# DESIGN COLLABORATIVE Pty Limited

28 May 2025  
Ref: 252145.2L

Submission on behalf of the Owners' Corporations of 'Metro Residences' – 'Metro View' (SP 88677) at 69 Albert St, 'Metro Spire' (SP 88678) at 1 Post Office Lane and 'Metro Grand' (SP 88679) at 438 Victoria Avenue, Chatswood – SSD-63324208 410-416 Victoria Avenue, Chatswood – Construction of a build to rent (BTR) development with ground and first floor retail premises, 260 BTR units, communal facilities and 3 levels of basement

SHADOW DIAGRAMS

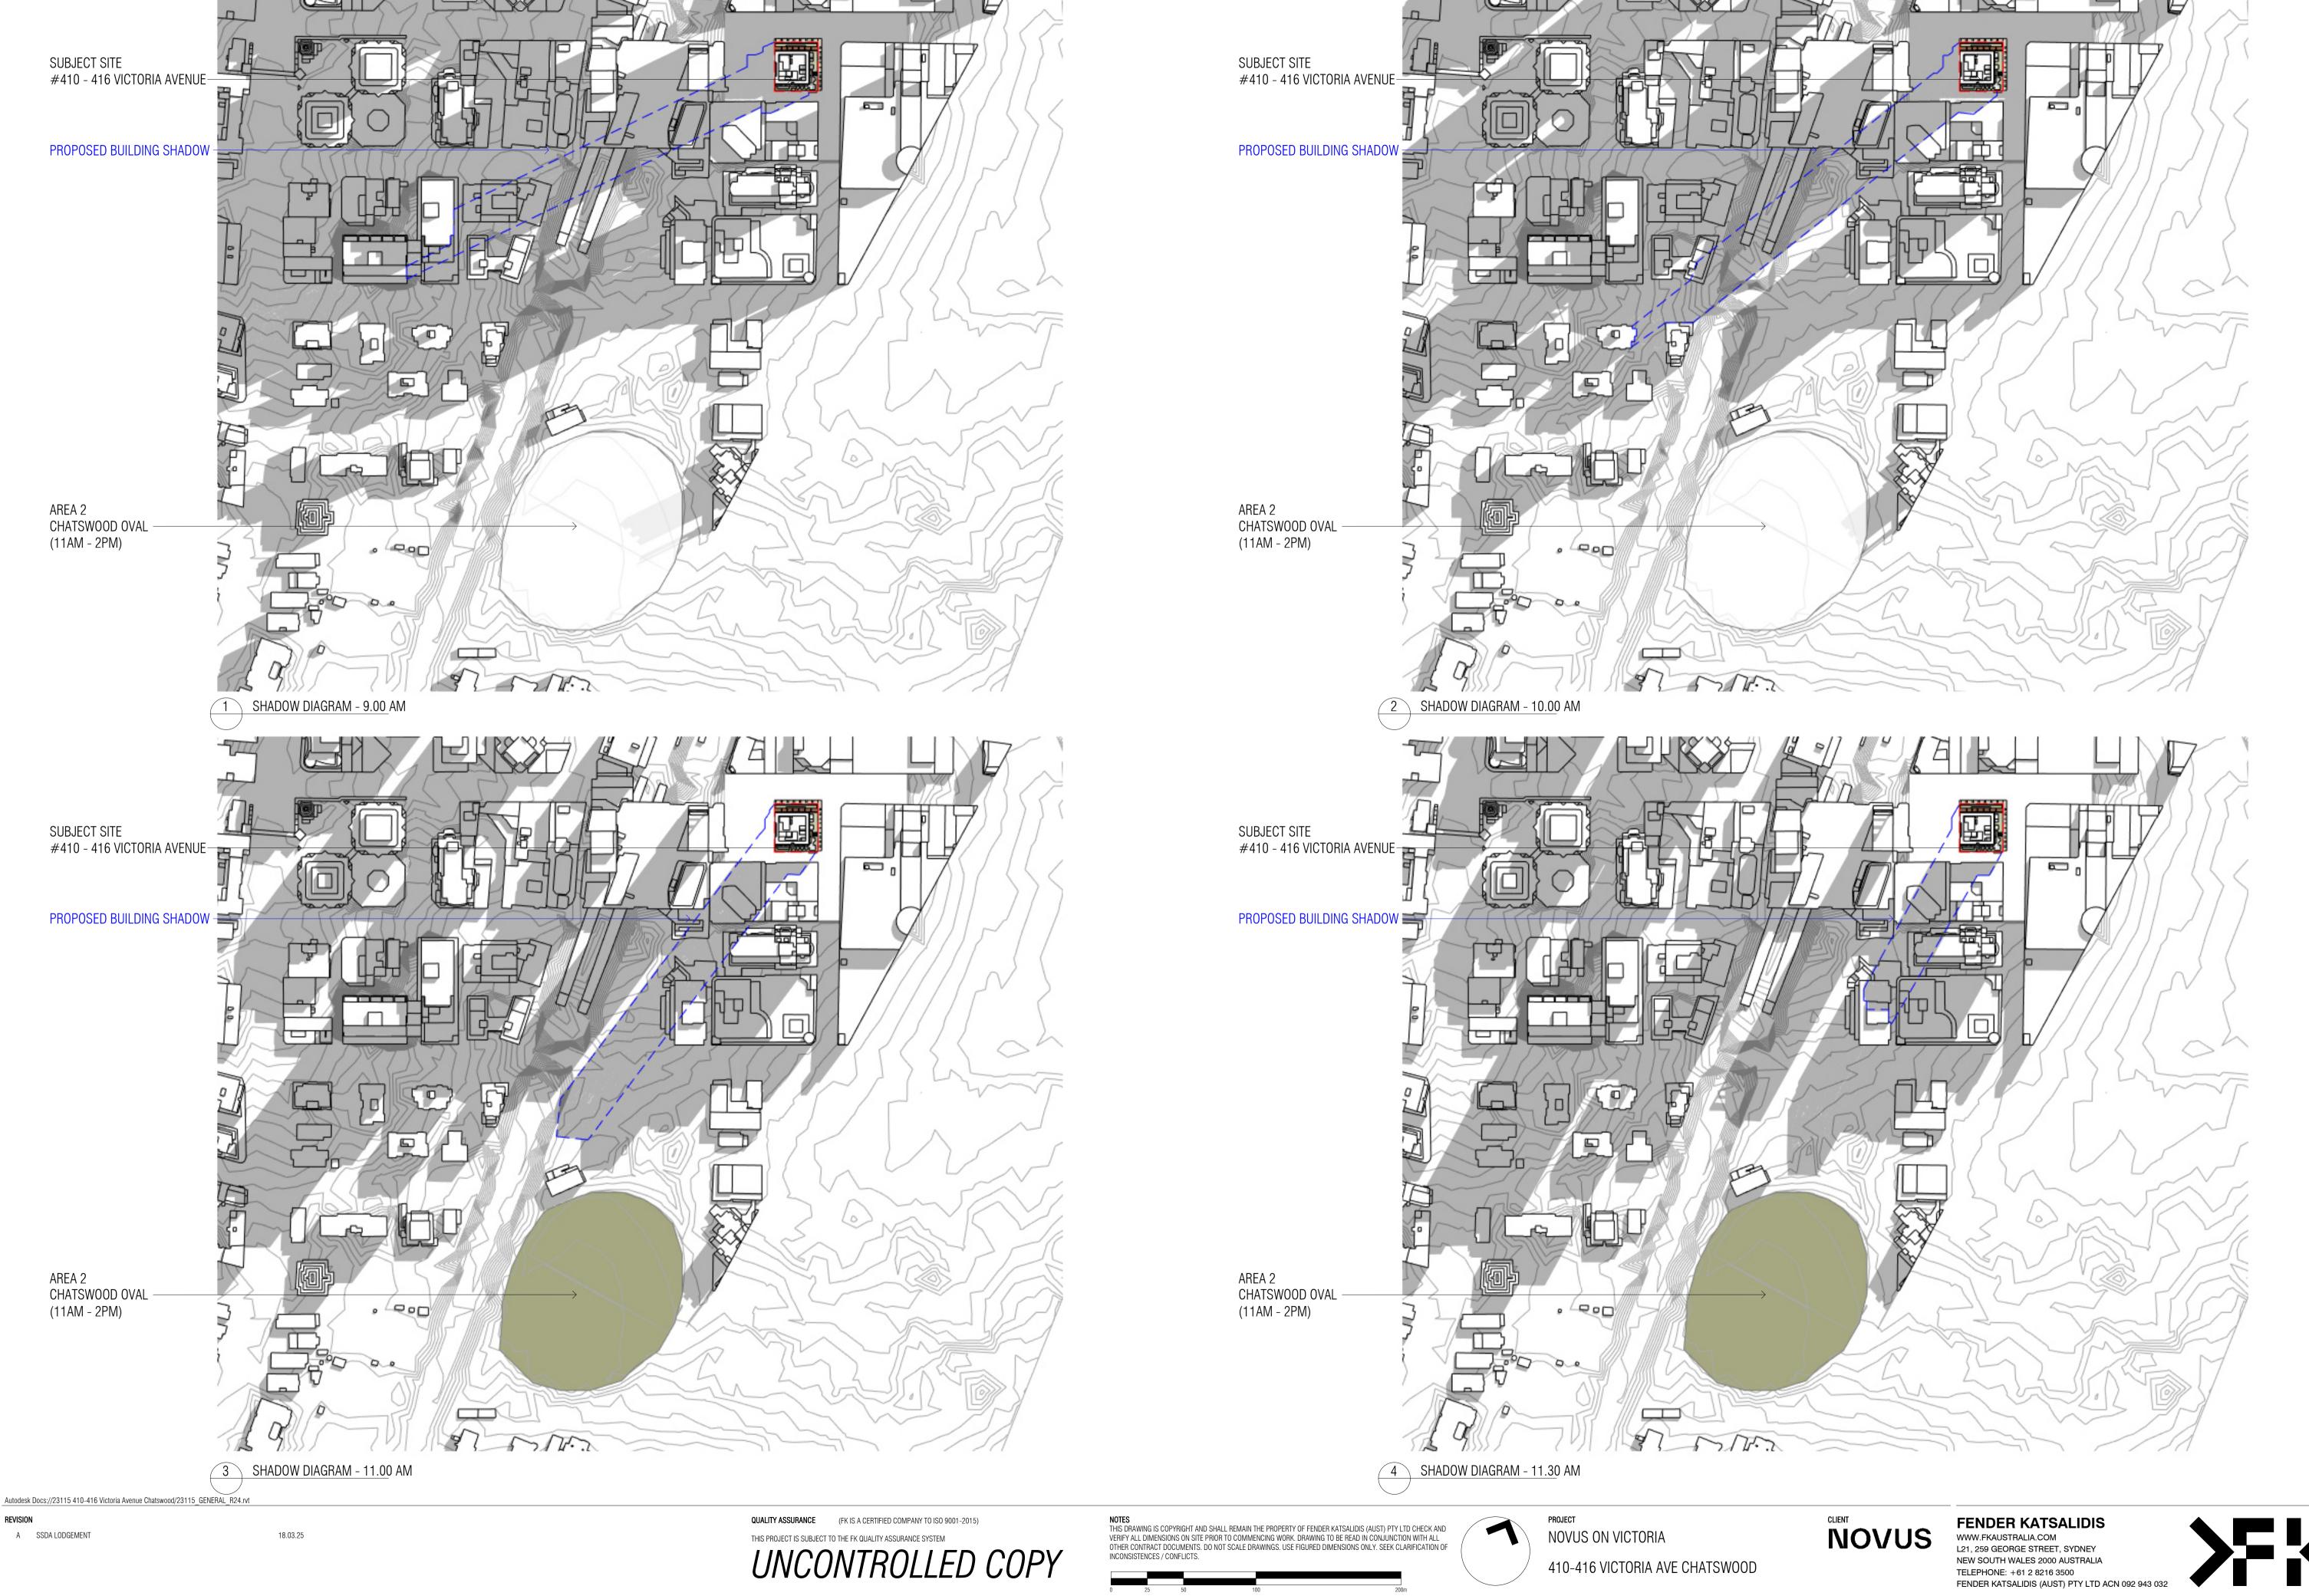
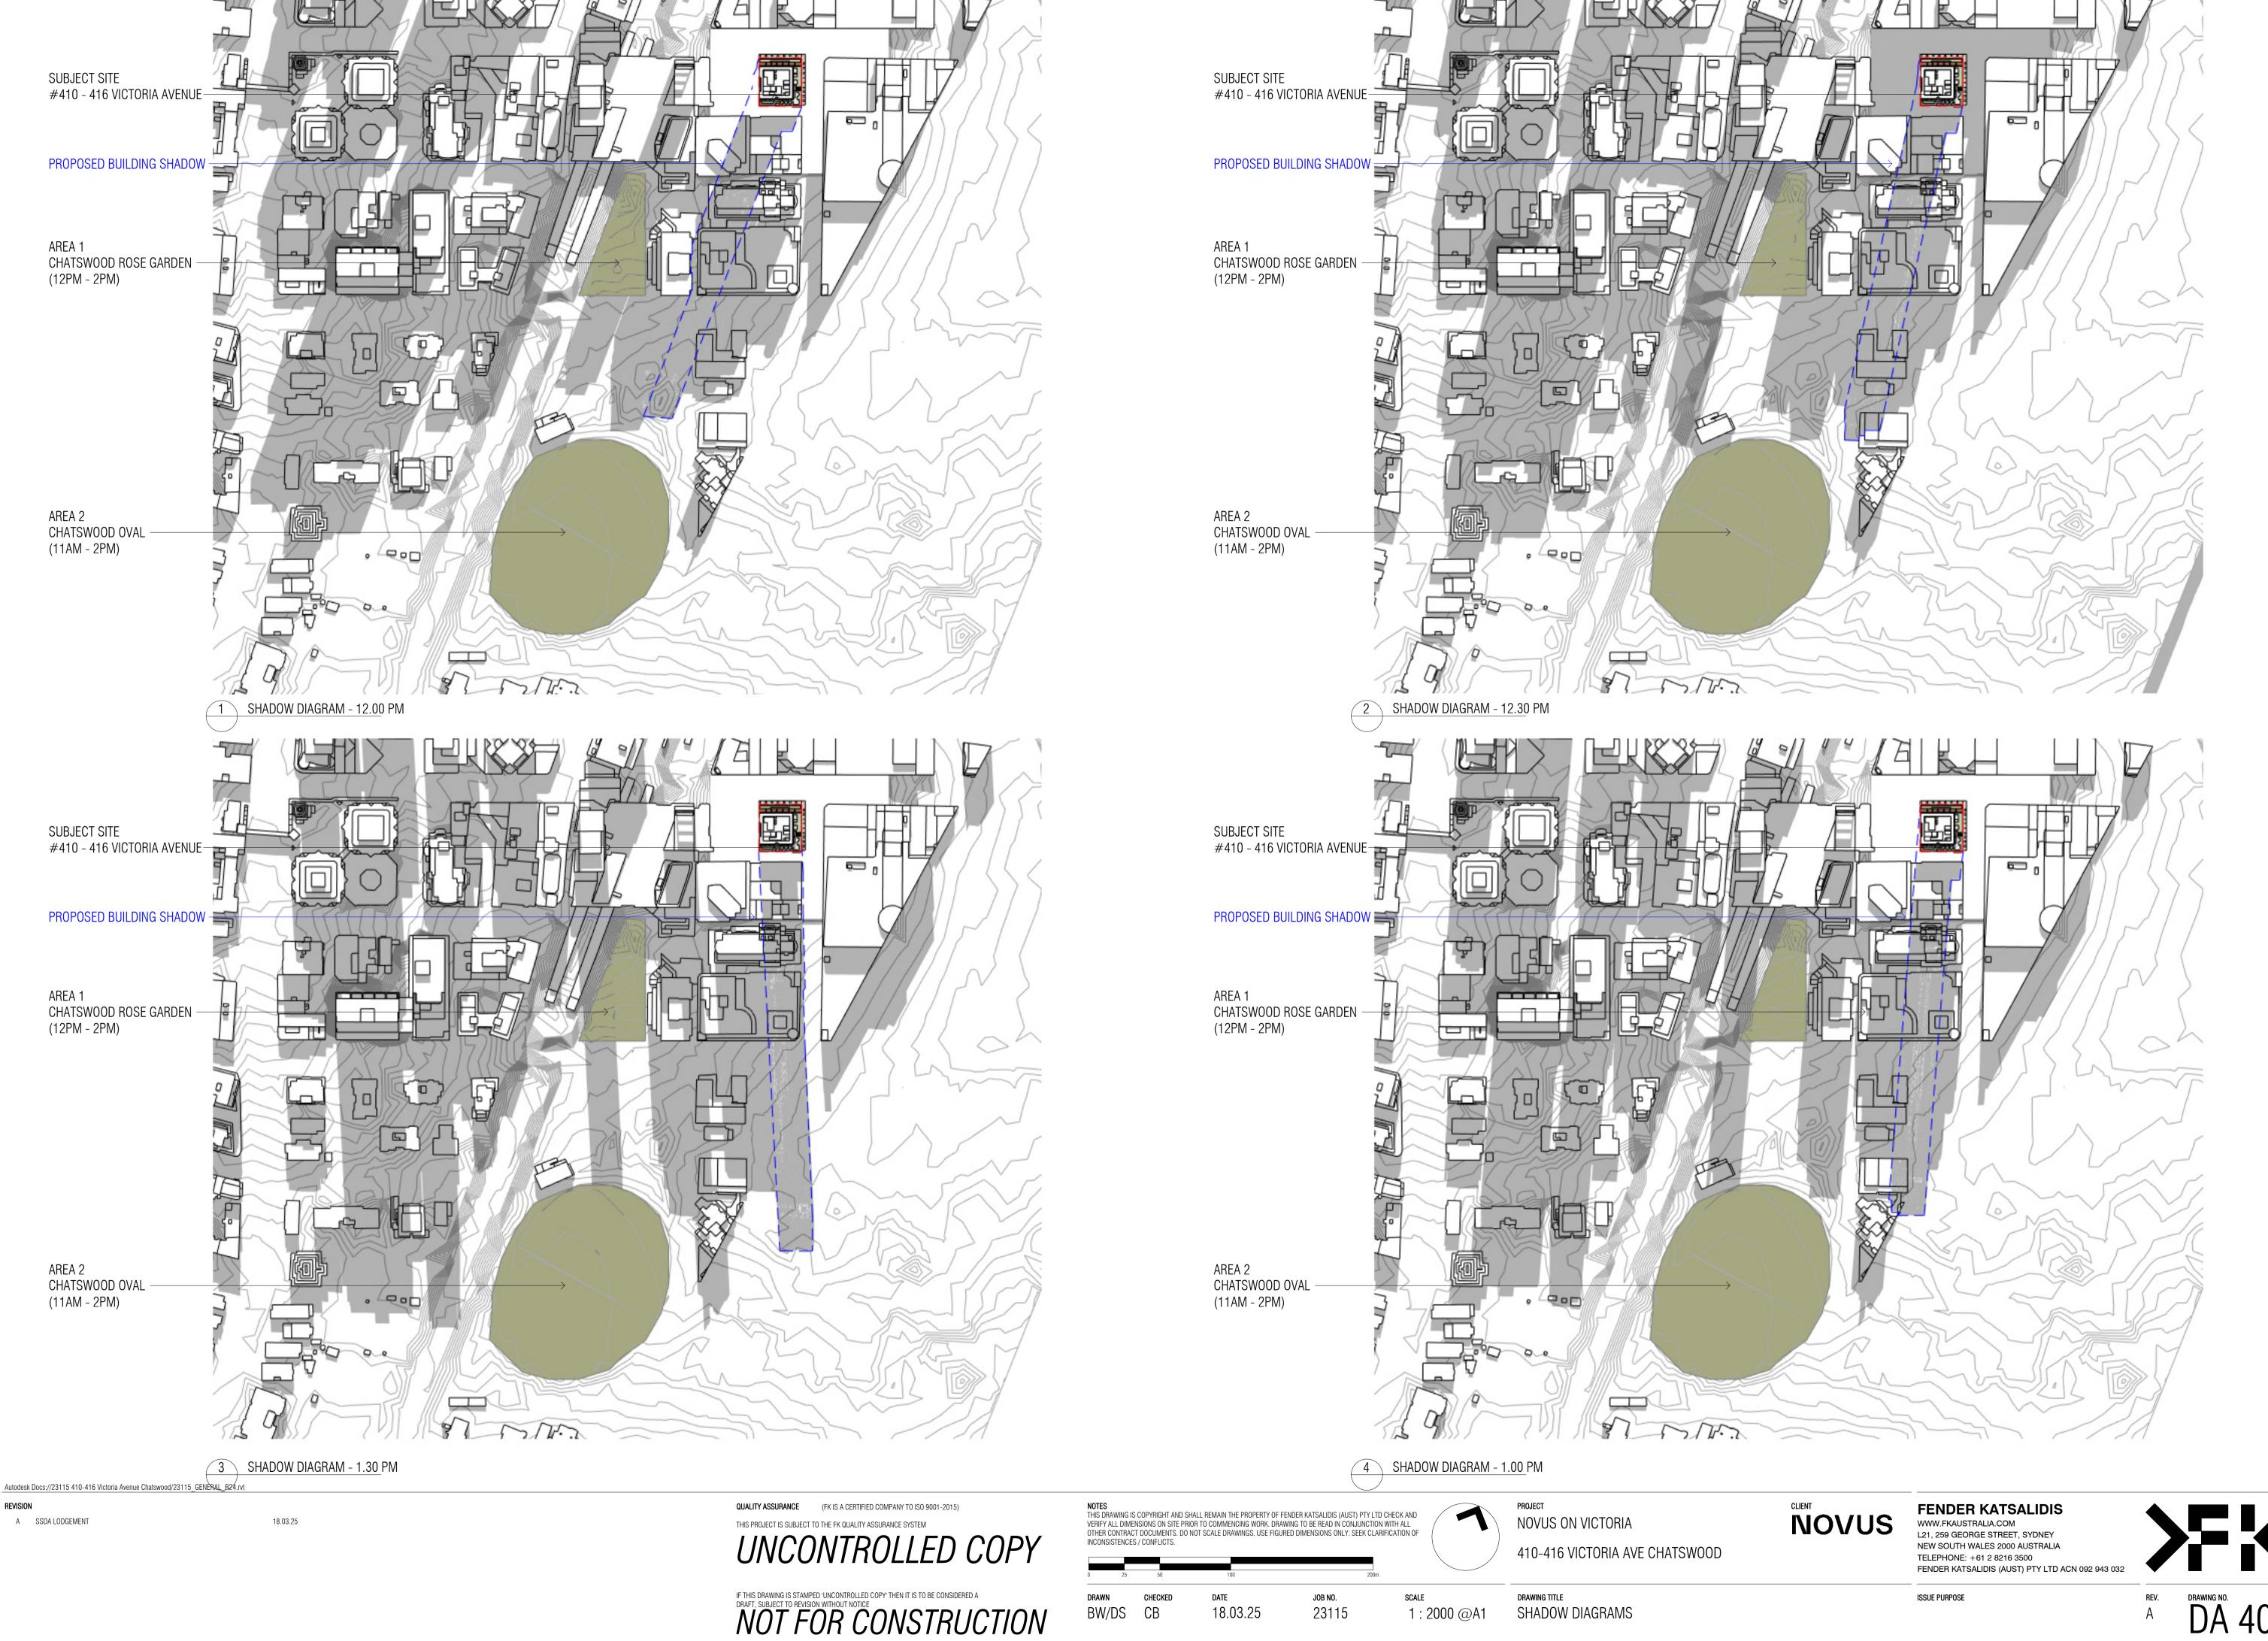
The proposal will result in additional overshadowing of Metro Spire and Metro View as shown in the midwinter shadow diagrams and 'Sun Eye View' diagrams from the EIS (p. 93)/architectural plans (see **Figures 2** and **3**).

The proposed SSD will have a significant adverse impact on the level of solar access achieved to the south-east-facing units in Metro View. The level of impact is such that these units will not achieve 2 hours solar access in accordance with the criteria under the ADG.

As shown above, at 9am and 10am, the proposal will overshadow most of the eastern façade of Metro View. At 9am, solar access is retained only to the SE corner of the building. At 10am, solar access is retained to the northern elevation/NE corner. This level of impact represents a significant and marked reduction in solar access to these units compared with the existing situation.

At 11am, the diagrams show there is no direct impact on Metro View and solar access is achieved to the eastern façade.

However, at 12 noon, due to the angle of the façade, the diagrams show that solar access would not be achieved to the south-east-facing units in Metro View.

Accordingly, the proposal will reduce the solar access of south-east-facing units in View such that they would not achieve the required 2 hours at mid-winter to living rooms/private open space. The 'as built' plans of Metro View indicate that there are units with living rooms and private open space at Levels 5-31 which would be adversely affected by this loss (see **Figure 4**). This will result in a significant loss of amenity to these units which currently achieve 2+ hours solar access throughout the morning.

It is submitted that the proposed development should be amended through provision of greater setbacks to the proposed tower to reduce its bulk so that the south-east-facing units in View achieve the minimum 2 hours solar access to living rooms/private open space. In addition, the assessment of compliance and impact should be revised and based on the actual unit layout within each of the buildings rather than on the basis of 'facades'. Without such an assessment the conclusions reached in the submitted SSD documentation cannot be relied upon.

As shown in the diagrams above, at 9am, the proposal will overshadow the SE corner of Metro Spire. By 10am, Metro Spire is not overshadowed. This overshadowing would affect the SE corner living rooms/wintergardens of units at each level of the building but is considered minor.
